LU/35/22/PL

The Nelson Hotel 61 Pier Road Littlehampton BN17 5LP

Alterations to elevations, rear extension and replacement of existing various roofs with new flat roof at second floor to provide refurbished and extended bar, restaurant, function room and guest accommodation.

Martyn White
Principal Conservation Officer,
Planning Services

Proposed Roof Plan

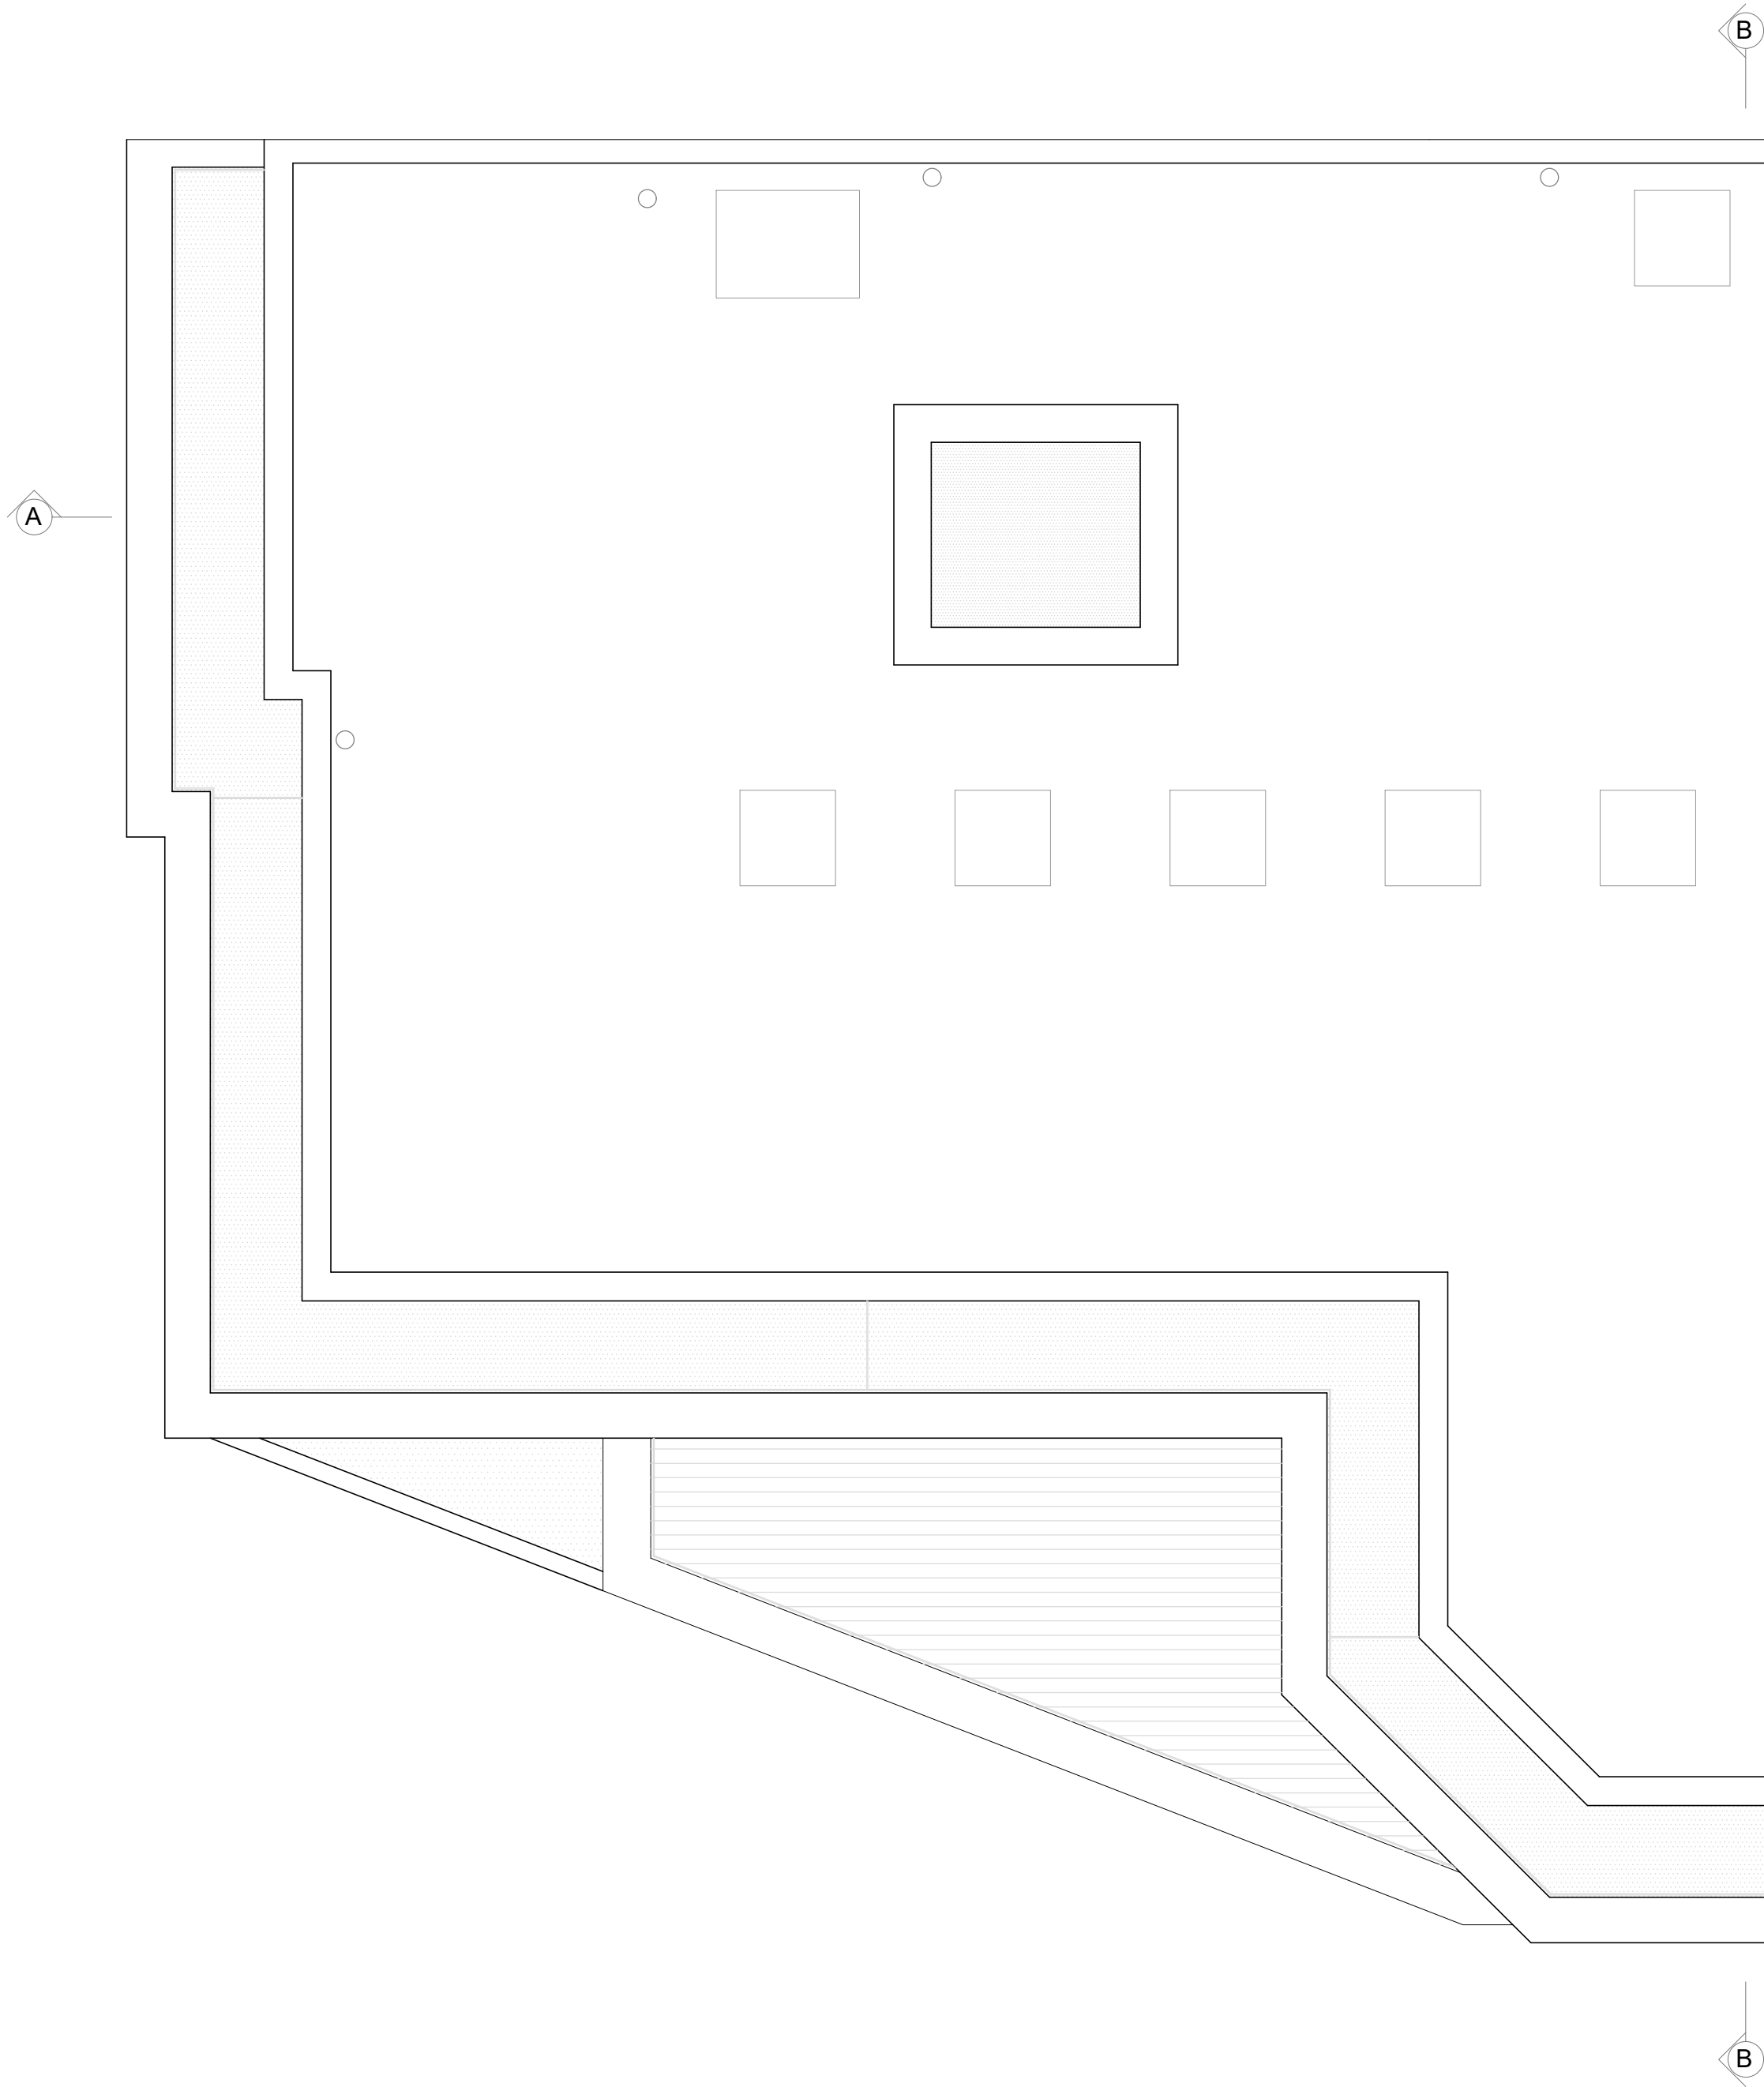
The large grey, top floor is another dominant feature which reads more as a flat roofed extension as opposed to a mansard roof, which could be a better design option. The mansard roof could be covered with a lead/lead alternative which would soften and improve in appearance with age.
